19/01091/LB

Applicant: Omlet Ltd

Proposal: Installation of insulation, ventilation slates and flat roof vents to existing roof

DRAWING No. 1936 - 02.A

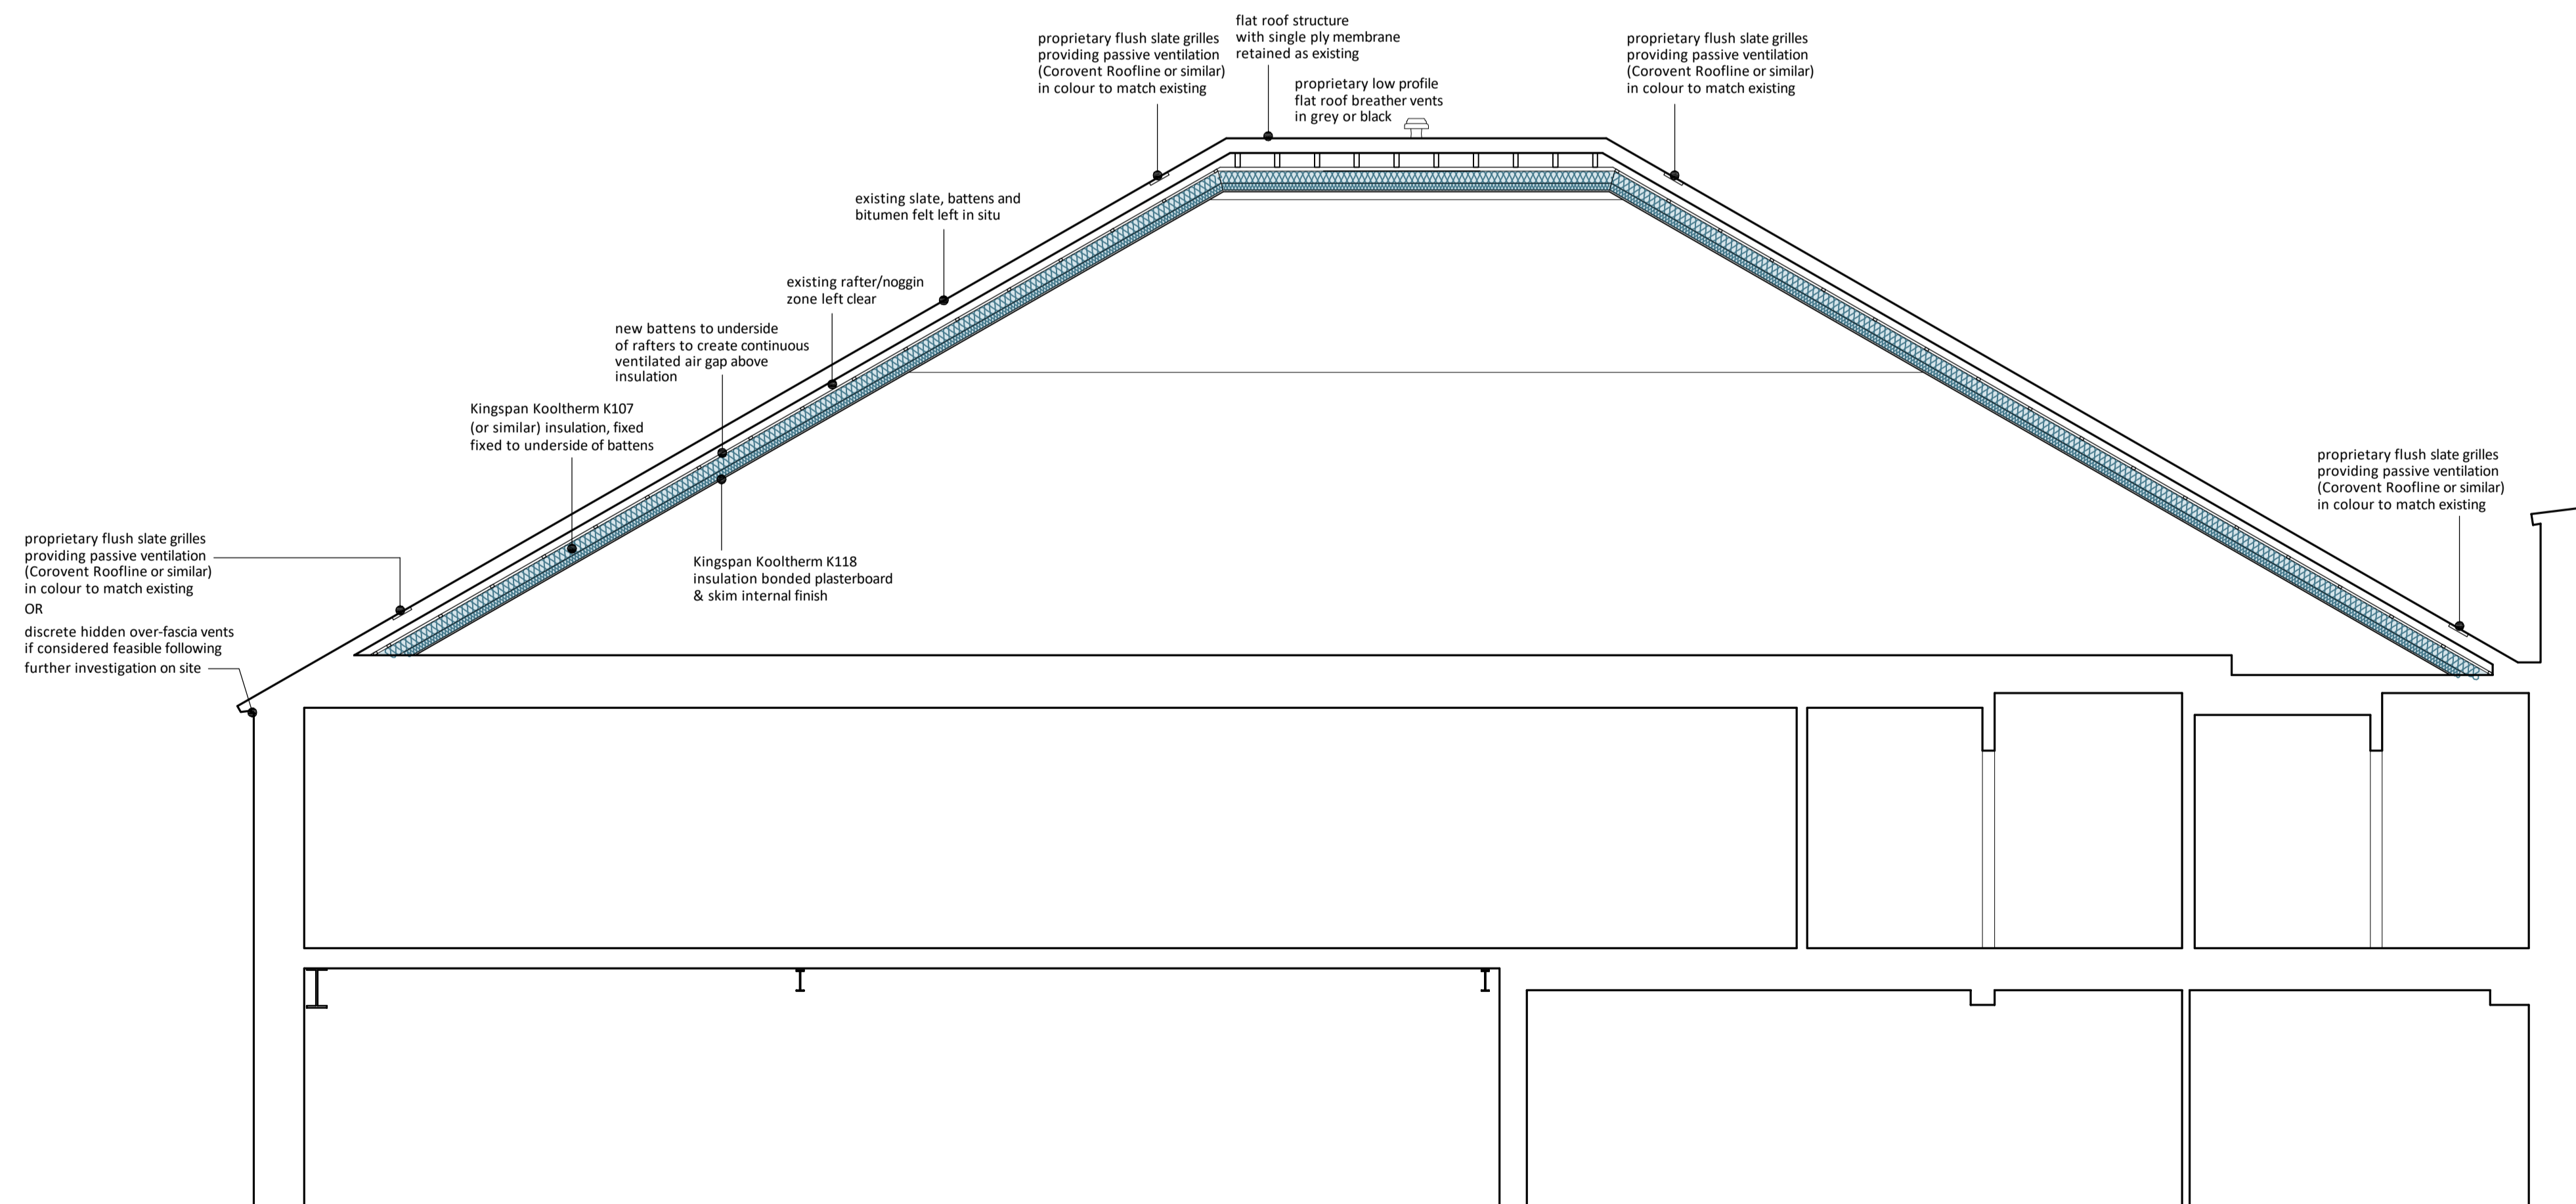
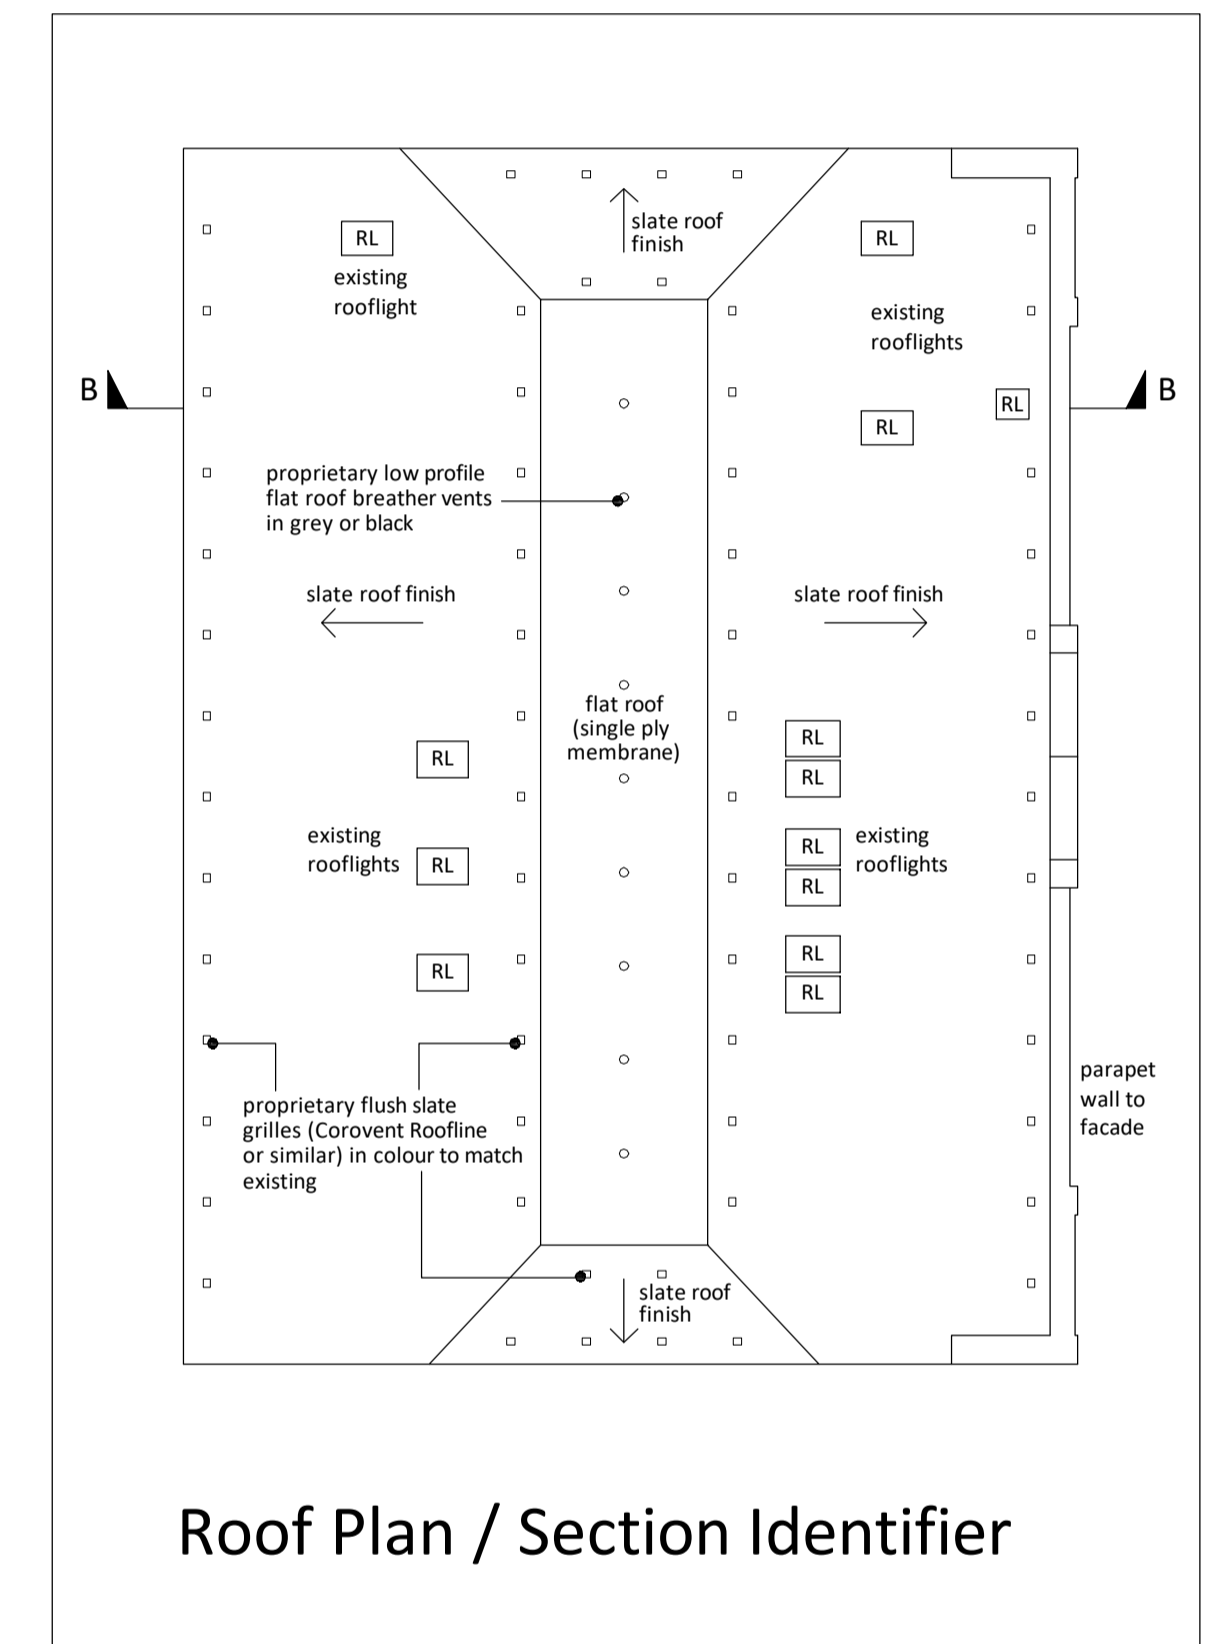
- 8.9. Drawing No. 1936-02.A states 'proprietary flush slate grilles providing passive ventilation (Corovent Roofline or similar) in colour to match existing or 'discrete hidden over-fascia vents if considered feasible following further investigation on site'. It is recommended that a condition is included for this detail to be agreed prior to installation.

3. Prior to installation of any roof vent, full details of the roof ventilation method shall be submitted to and approved in writing by the Local Planning Authority. The works shall be carried out in accordance with the approved details.
